Online Comment

Application H16-1319-21
Location 11 MARKET PLACE SPALDING PE11 1SP
Proposal Internal alterations and conversion from Class E to mixed use Class E/Class C (12 residential units)

Name Pedals c/o Roger Smith
Address 18 Cley Hall Drive Spalding PE11 2EB

Date Submitted 01-02-22
For/Against Comments

Level 00 - Ground Floor - Proposed

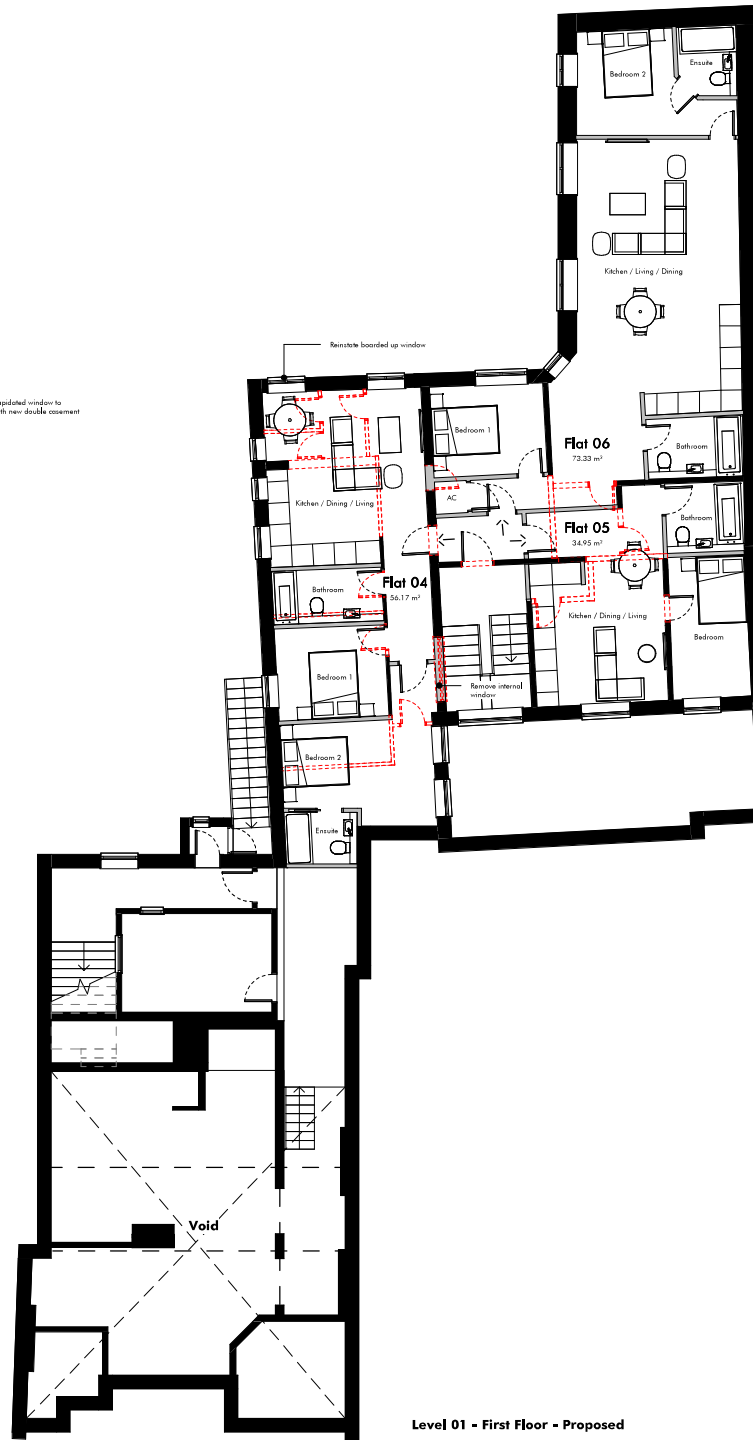
It is good to see facilities for storing bicycles included in this application.
If permission is granted please include a condition requiring the facilities for storing bicycles to be provided and available for use before the building is first occupied.
